DEVELOPMENT REVIEW BOARD
SUPPLEMENTAL SUBMITTAL

PROJECT NO. PR-2021-005019
Application No. SD-2021-00109

Re: Final plat for Proposed Tract A, Lowe's Markets being comprised of Tract A-2, Lands of Mountain States and Telegraph Company; Tracts A of Furr's Properties Inc., and Lots 1-5 and 11-17 of Rivera Place, and a vacated portion of Rivera Place Drive N.W.

**Plat for
Tract A, Lowe's Markets
Being Comprised of
Tract A-2, Lands of Mountain States Telephone
& Telegraph; Tract A, Furr's Properties Inc.,
Lots 1-5, and Lots 11-17, Rivera Place, and a
Portion of Vacated Rivera Pl. Dr. N.W.
City of Albuquerque
Bernalillo County, New Mexico
May 2021**

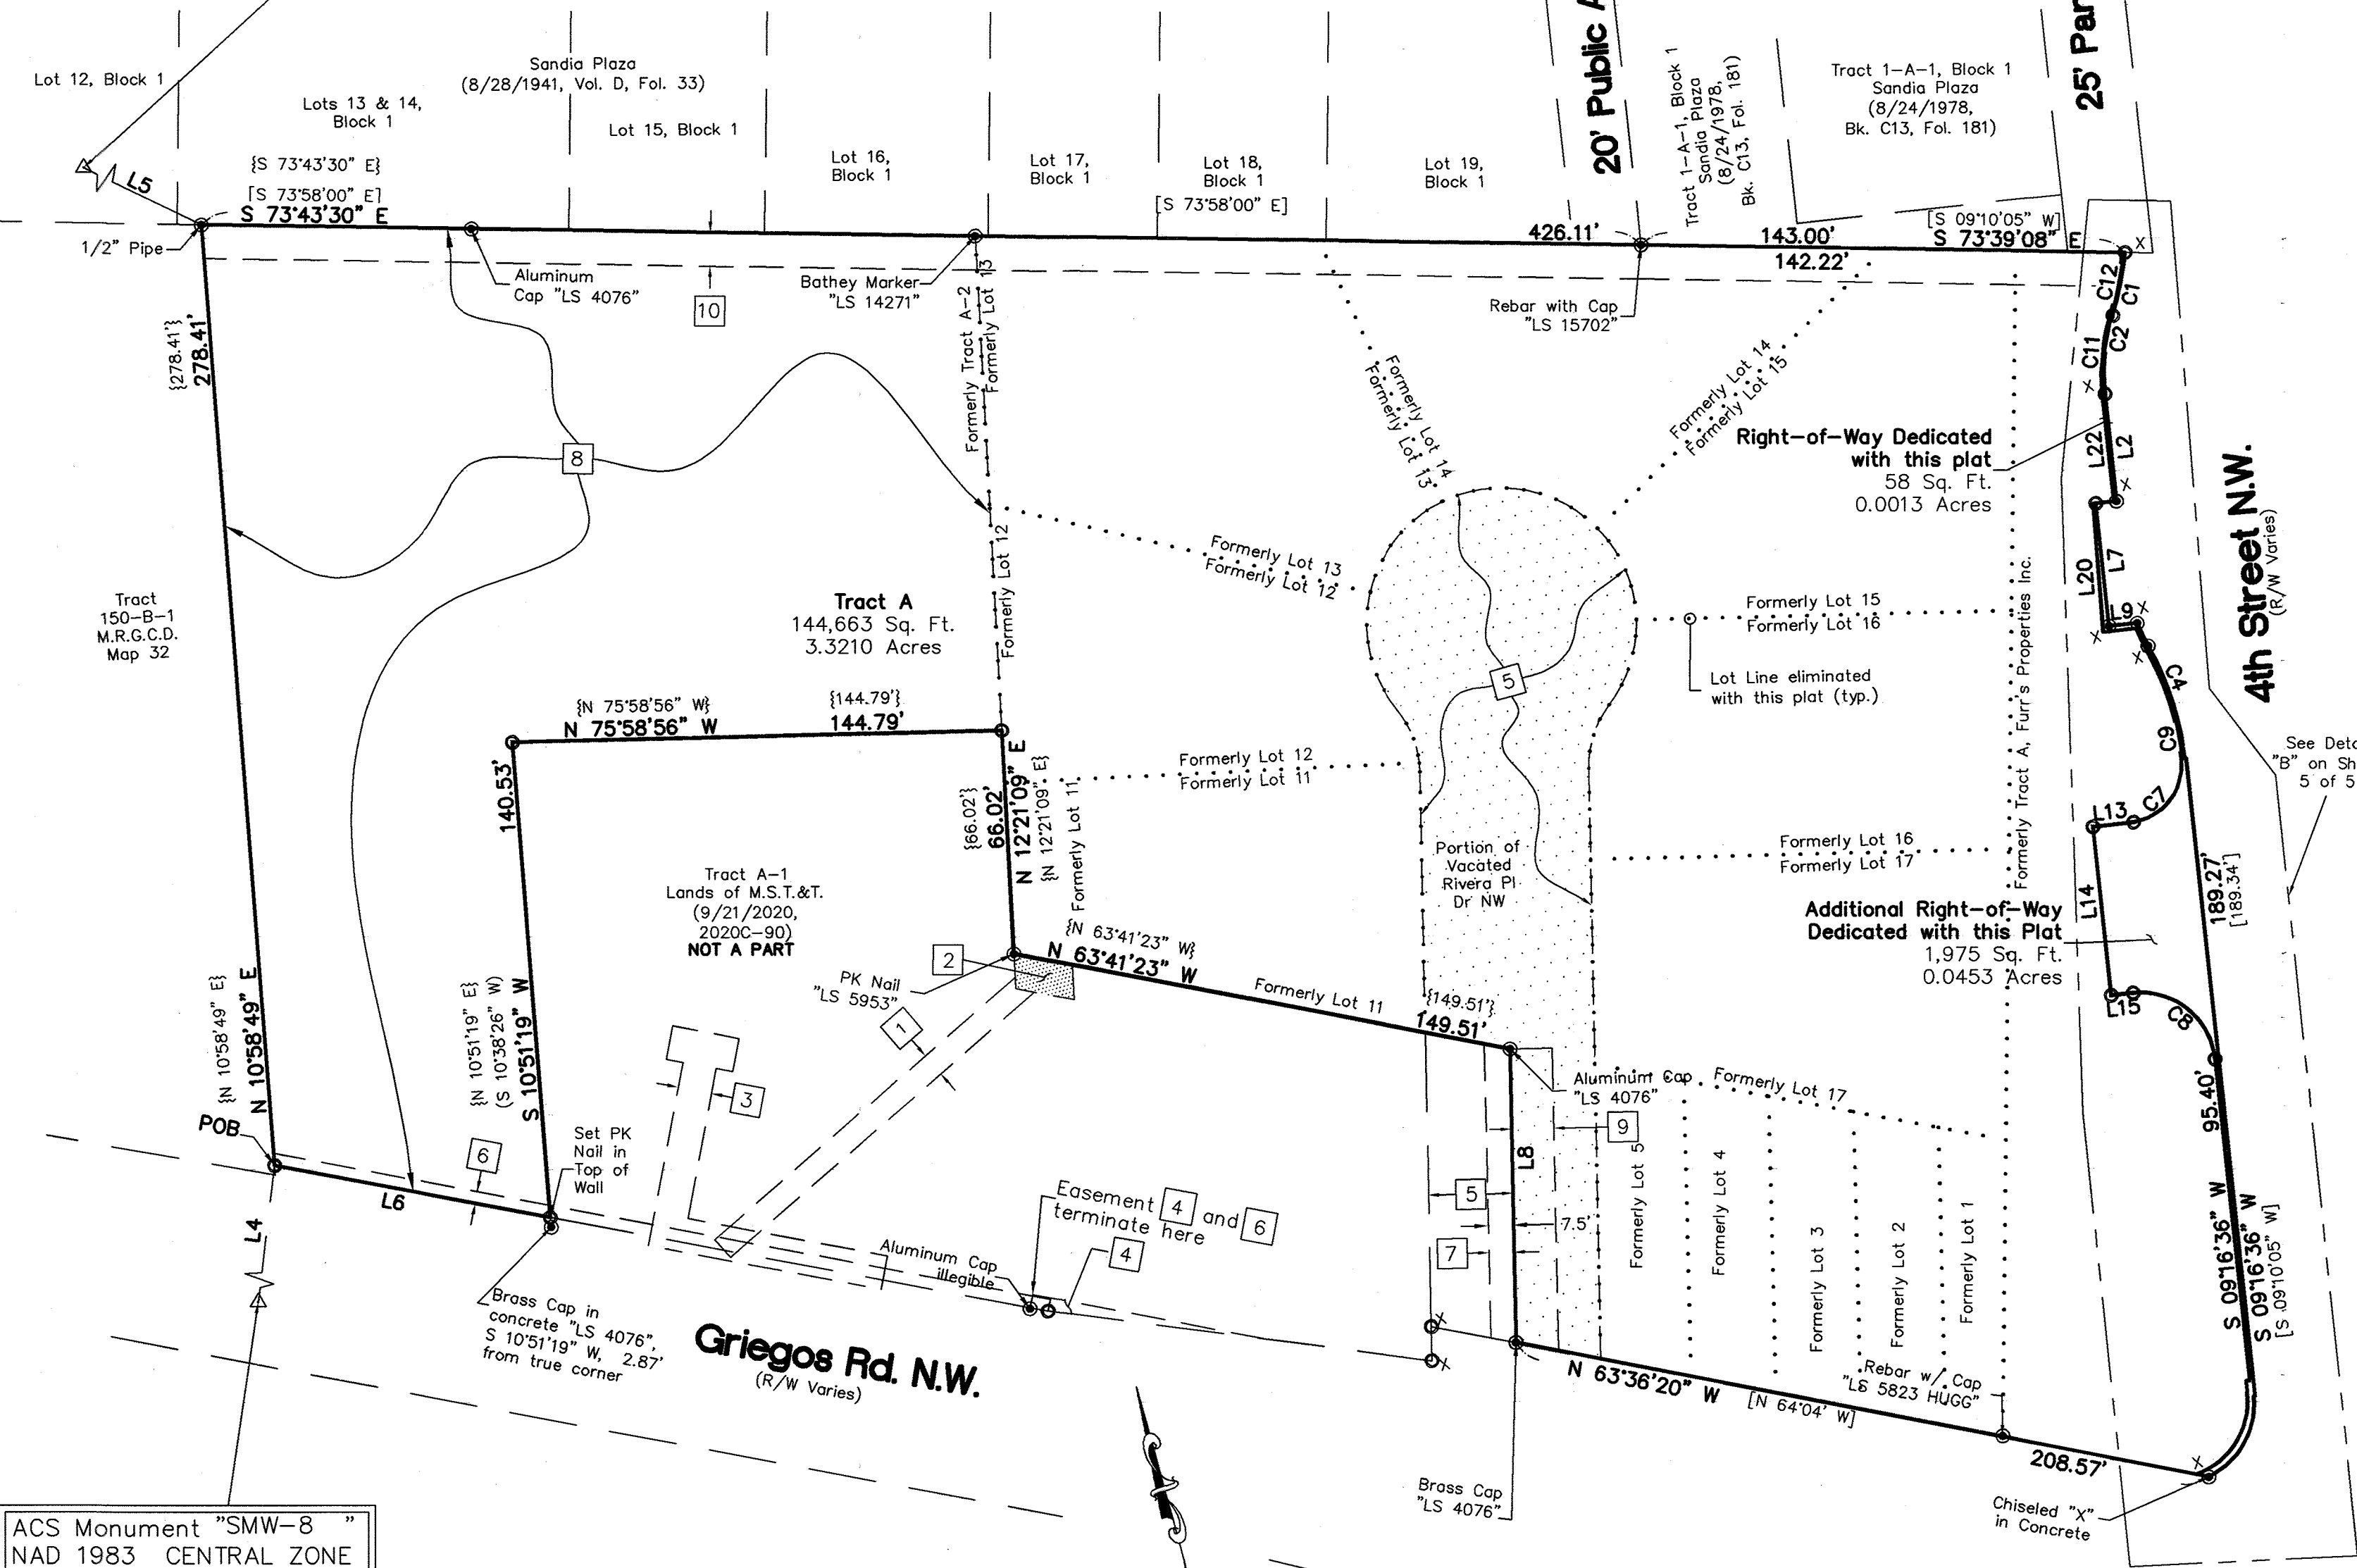
1. Please add MRGCD signature line with other signatories on page 1.

2. Please add MRGCD Approval Note to page 1 of plat.

Signature line is present on page 1 for MRGCD.

Approval note added to page 1 of plat.

**Plat for
 Tract A, Lowe's Markets
 Being Comprised of
 Tract A-2, Lands of Mountain States Telephone
 & Telegraph; Tract A, Furr's Properties Inc.,
 Lots 1-5, and Lots 11-17, Rivera Place, and a
 Portion of Vacated Rivera Pl. Dr. N.W.
 City of Albuquerque
 Bernalillo County, New Mexico
 May 2021**

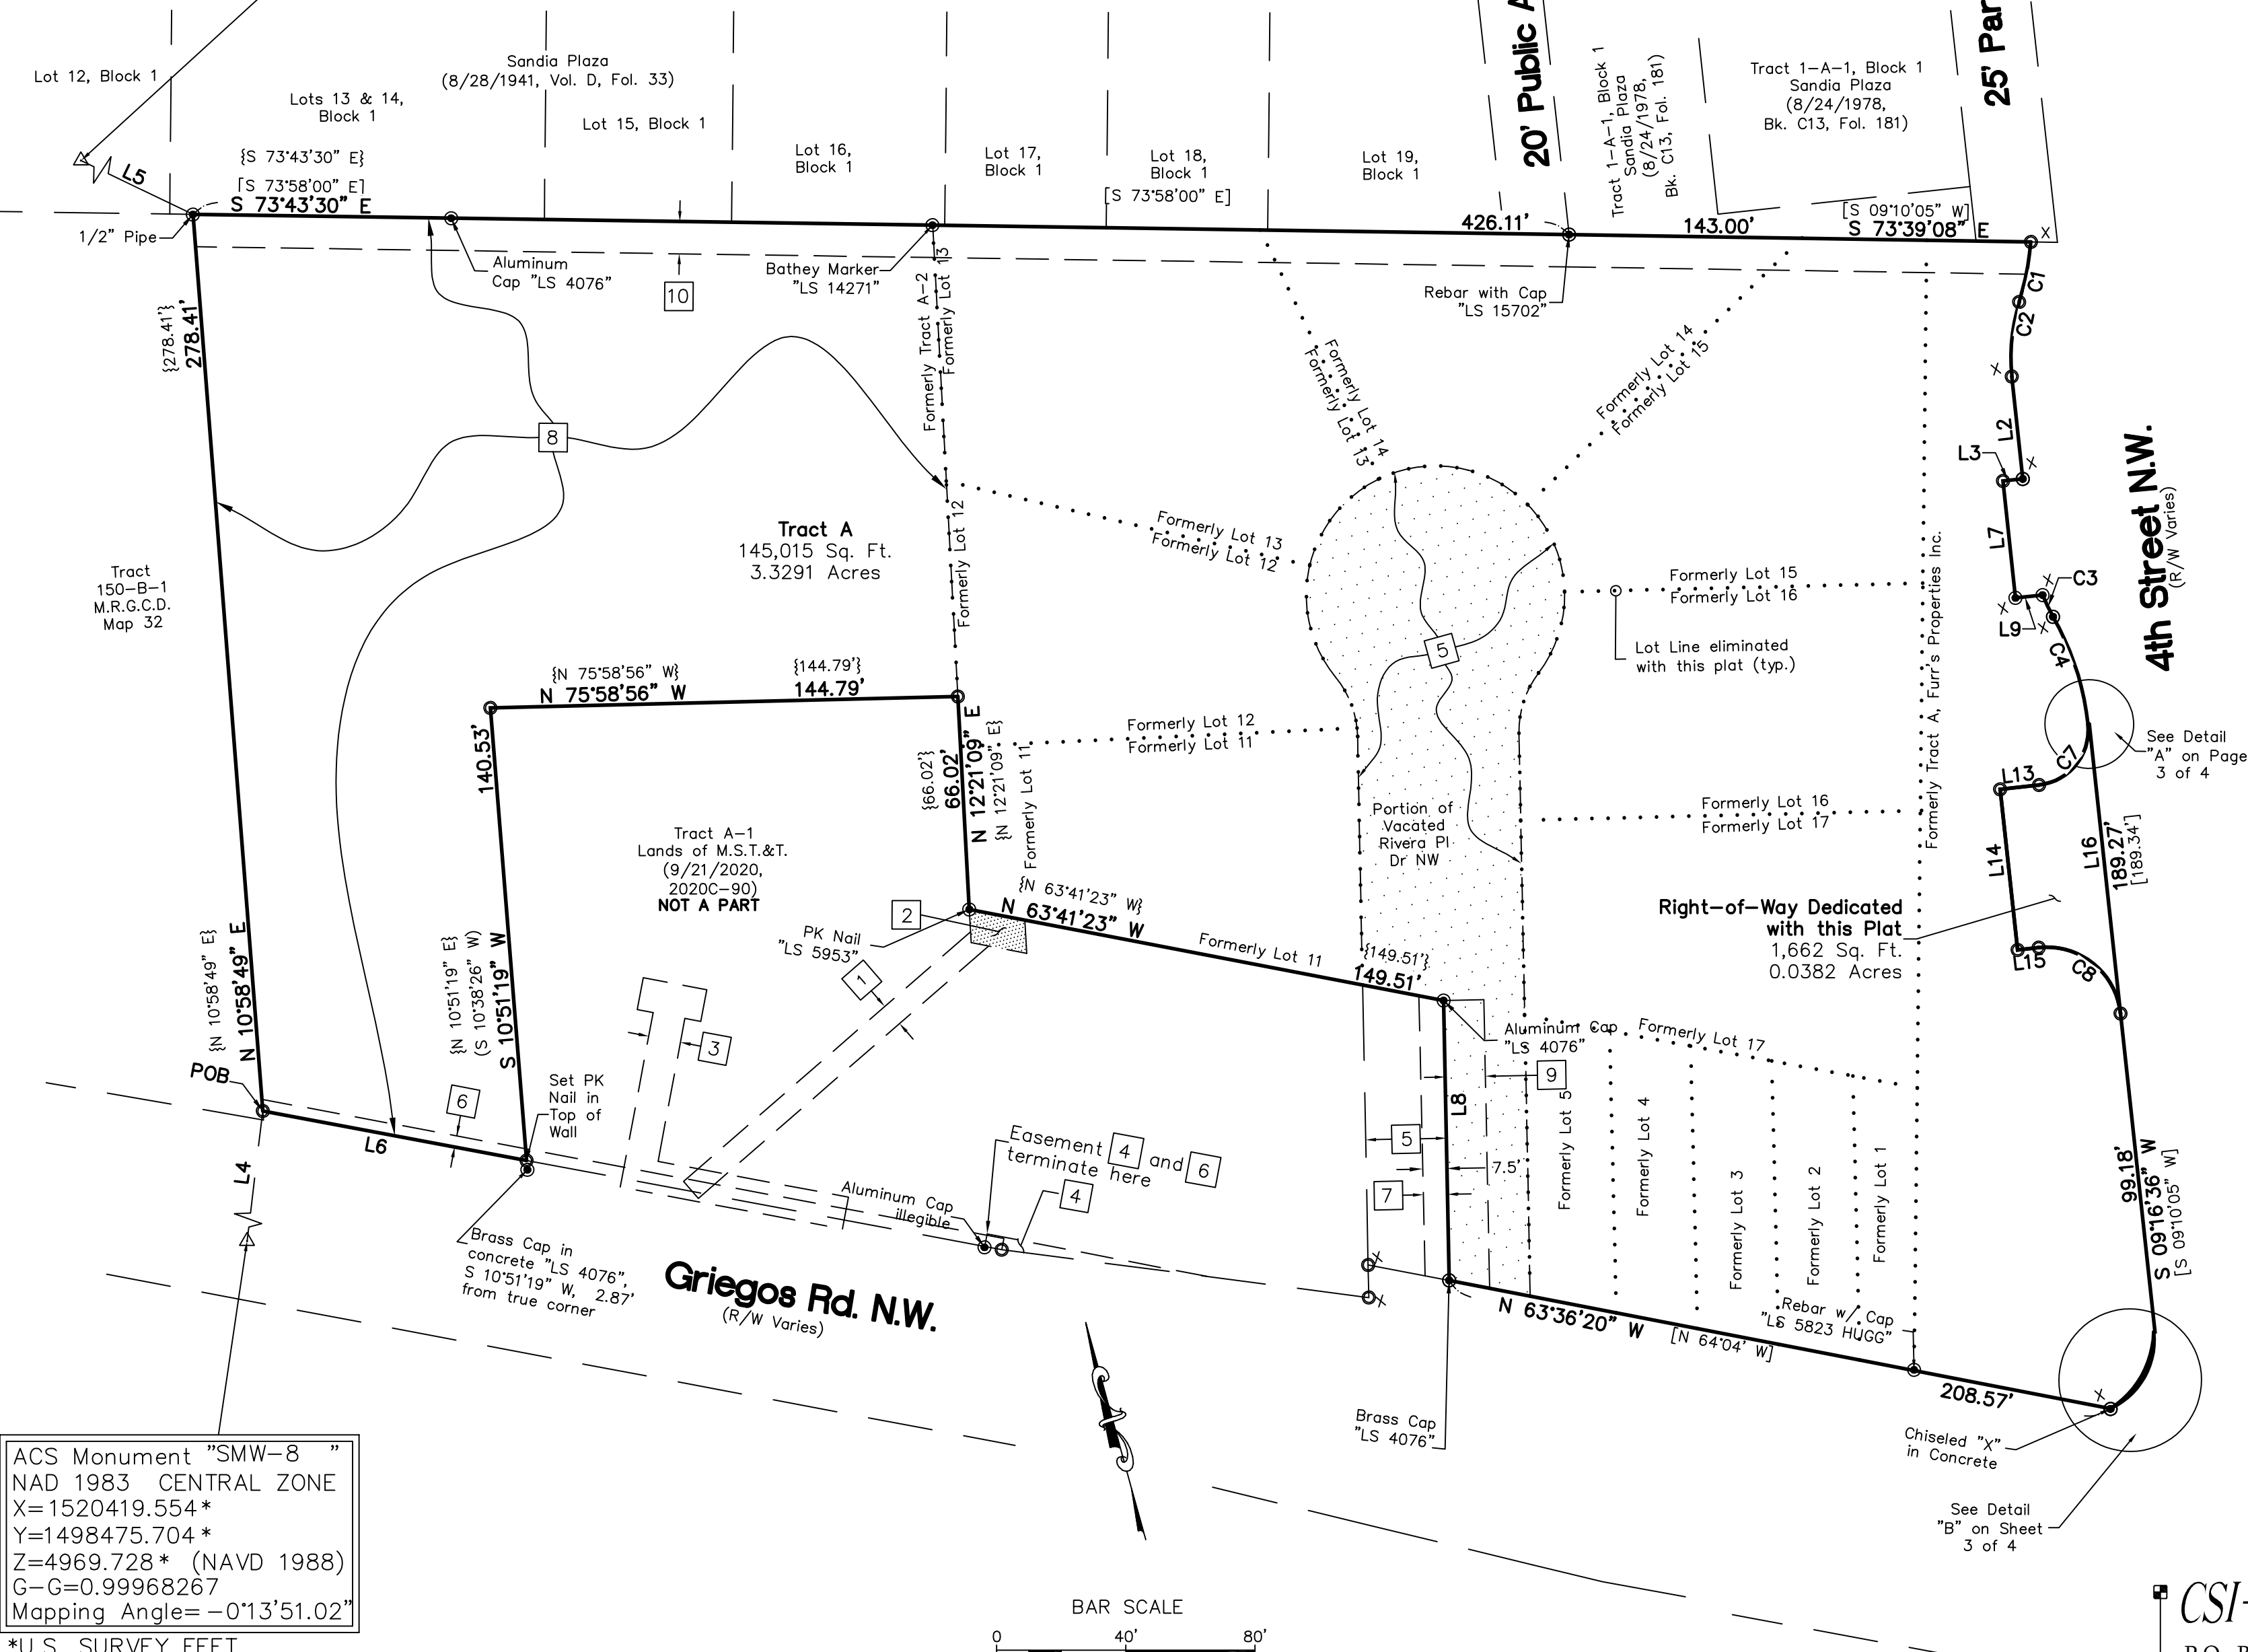
1. ABCWUA suggests deferral this vacation contingent upon the internal processes to reclassify the sewer line as private are completed.

1. Utility Development Section is meeting with ABCWUA legal on the required format of an approval or agreement to transfer the sewer main to private. This is required to be completed prior to ABCWUA approving the plat. A formal approval is required so that we may properly updated our asset management records.
2. Public water and public sewer mains are present in all of the plat area's frontages.

Sewer line abandonment document has been signed and is attached with this supplemental application, so vacation of public easement should be approvable.

Sewer line abandonment document has been signed and is attached with this supplemental application, so vacation of public easement should be approvable.
